Project Name: Crystal Ridge, Unit 1

**CITY OF ALBUQUERQUE  
PLANNING DEPARTMENT  
Development Review Board  
June 30, 2004 Comments**

**RE: Lot 14A, Block 3, Unit 1, Crystal Ridge/minor plat**

PLAT FOR
LOT 14A1-P1
BLOCK 3
CRYSTAL RIDGE SUBDIVISION, UNIT 1
WITHIN THE
TOWN OF ALAMEDA GRANT
PROJECTED SECTION 7
TOWNSHIP 11 NORTH, RANGE 3 EAST, NMPM
CITY OF ALBUQUERQUE
BERNALILLO COUNTY, NEW MEXICO
APRIL, 2004

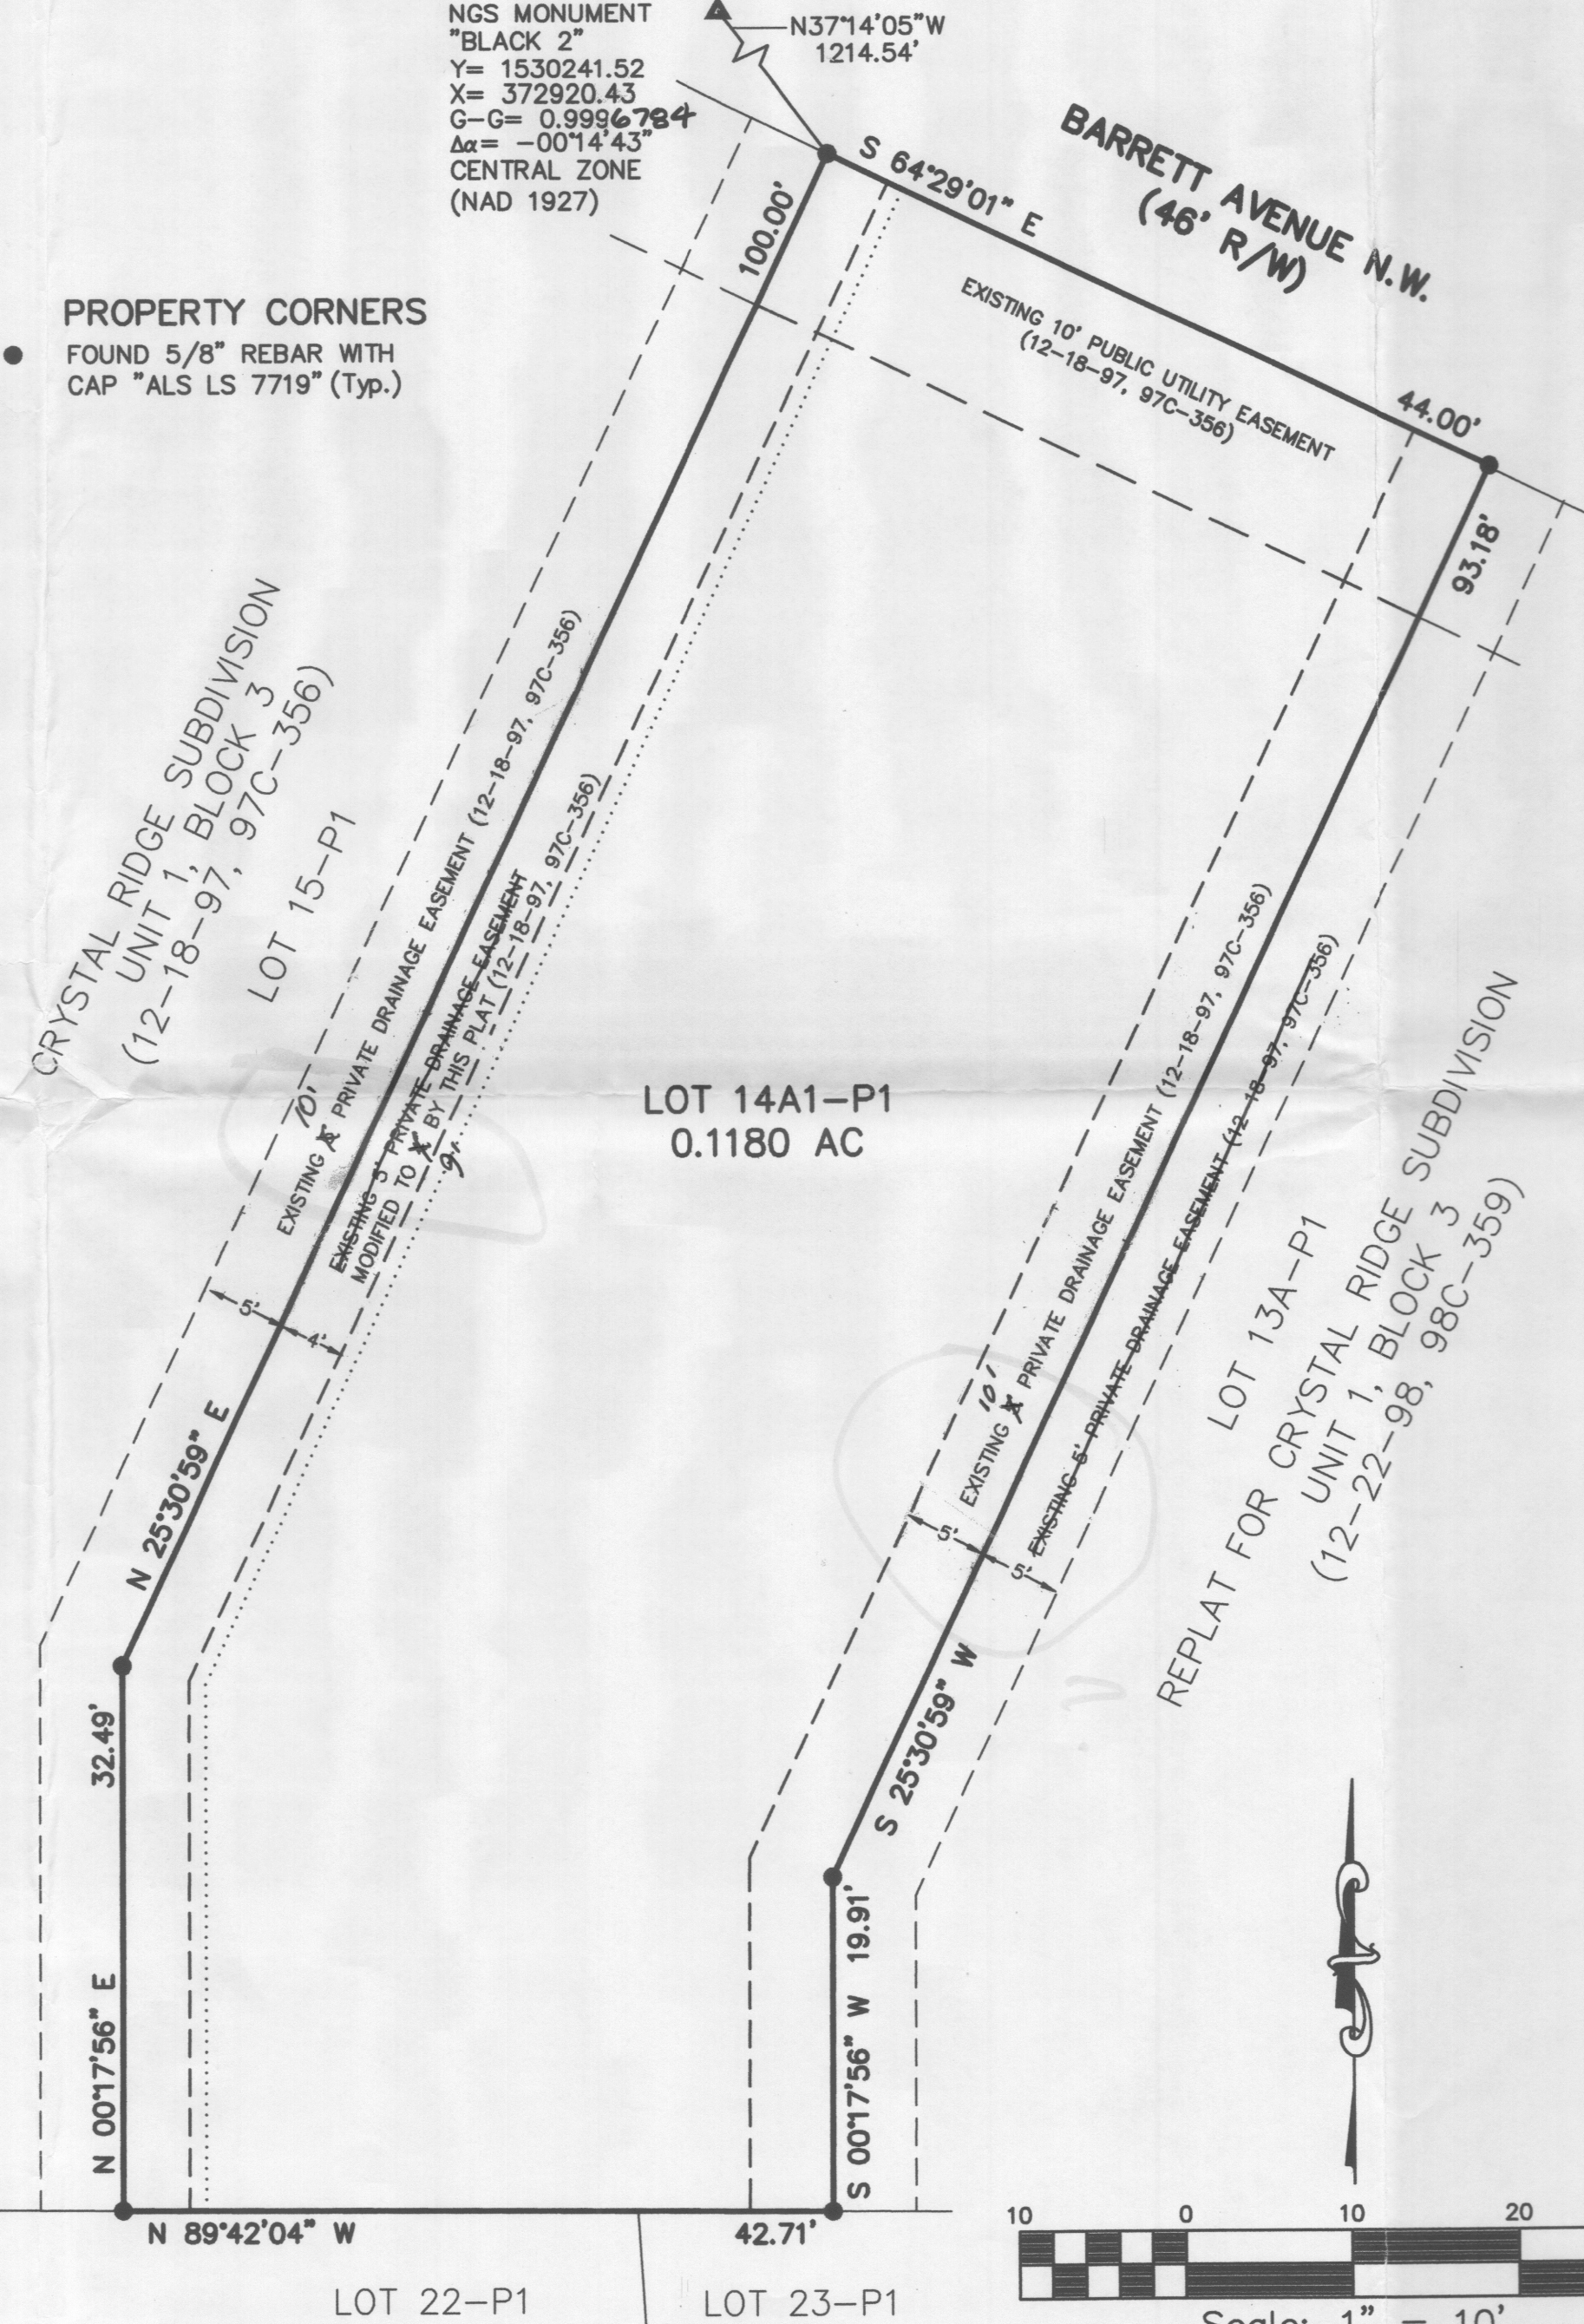
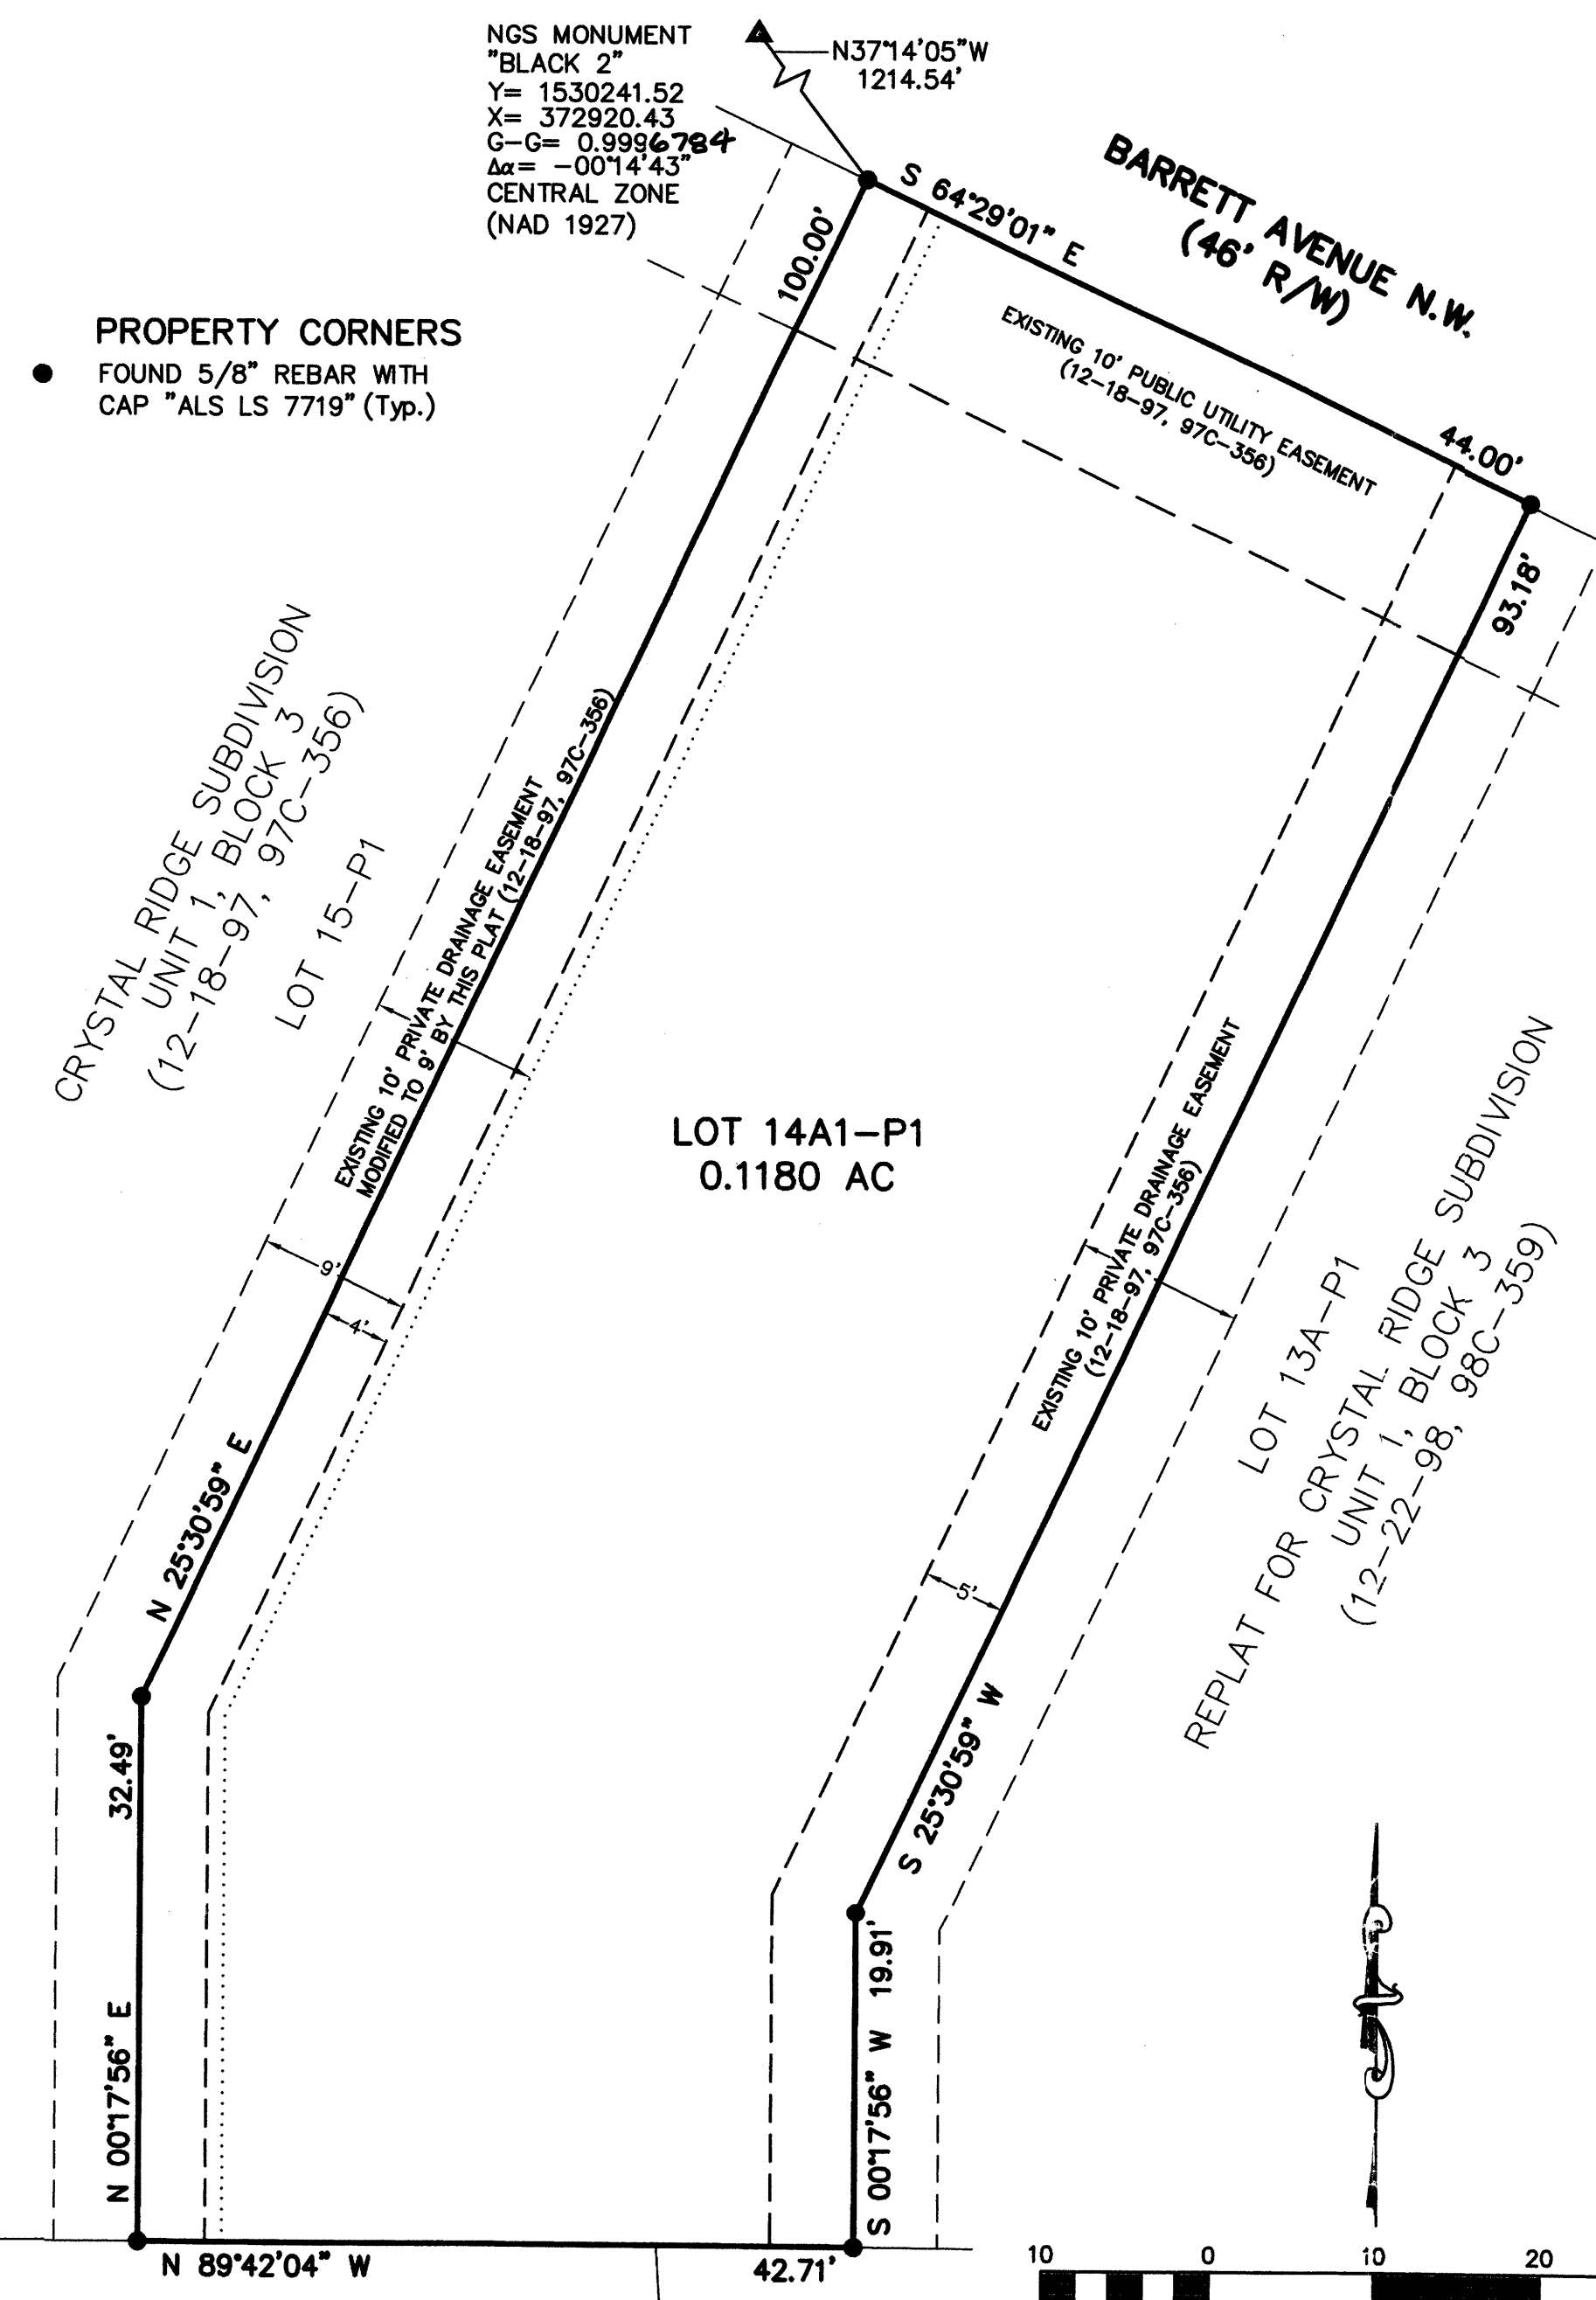
○ Have all the beneficiaries of the private easement being vacated agreed to the vacation?

There is no vacation exhibit. Planning needs one clearly marked for its file. The plat shows some different dimensions for the drainage easements but is not clear on the intent. Before Planning can sign the plat, a clear exhibit is required.

Language to be added to the plat above the owner's signature:

"Said owners warrant that they hold complete & indefeasible title in fee simple to the land subdivided."
